WEST SUSSEX COUNTY COUNCIL CONSULTATION

TO:	Arun District Council FAO: Simon Davis
FROM:	WSCC - Highways Authority
DATE:	15 June 2021
LOCATION:	Land at Street Buildings North End Road Yapton BN18 0DT
SUBJECT:	Y/74/21/DOC Approval of details reserved by condition imposed under ref Y/146/20/RES relating to Condition Nos 3 - in-curtilage storage spaces for houses & maisonettes, 4 - elevation & floor plan details of the proposed detached garages and 7 - external lighting.
DATE OF SITE VISIT:	n/a
RECOMMENDATION:	Advice
S106 CONTRIBUTION TOTAL:	n/a

Title:
PARKING AND CYCLE STORAGE PLAN

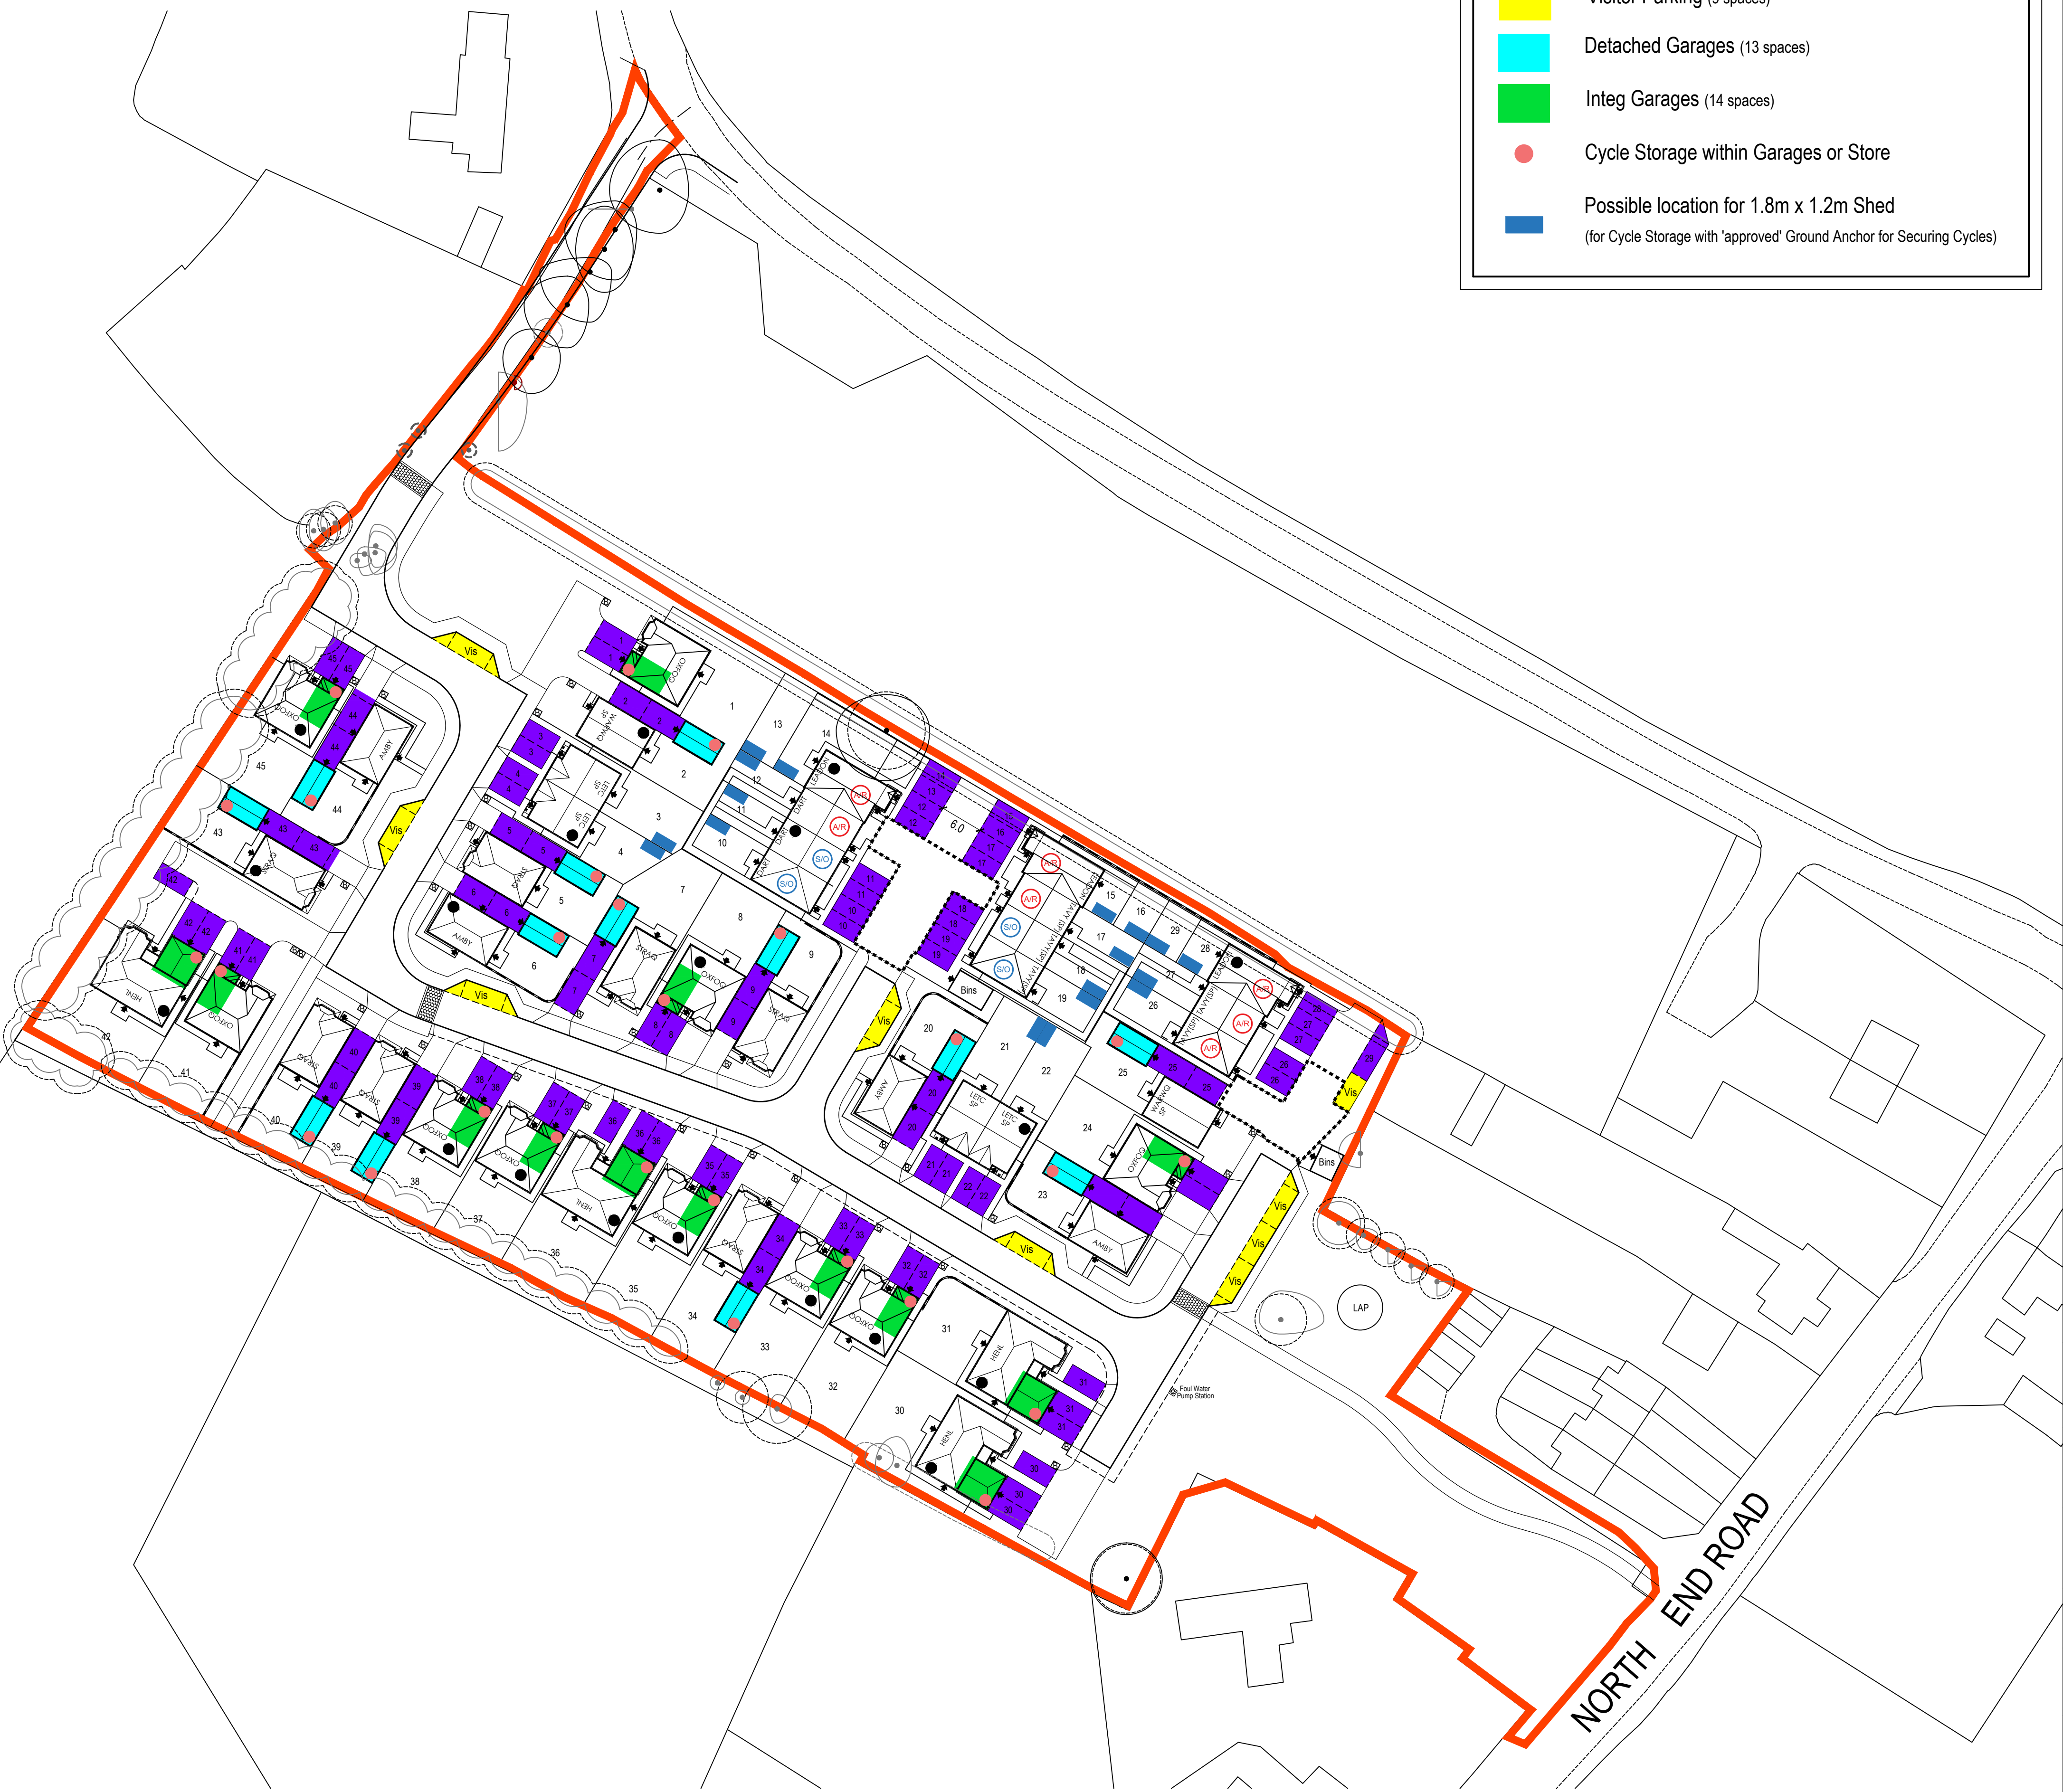
For the purposes of this application the Local Highway Authority (LHA) will comment on Condition 4 of the original consent. This relates to the sites garage dimensions these have been shown on Drawing '90' within the submitted information. The LHA would be satisfied with the proposed dimensions and each garage has sufficient space for secure and covered cycle parking within the garage.
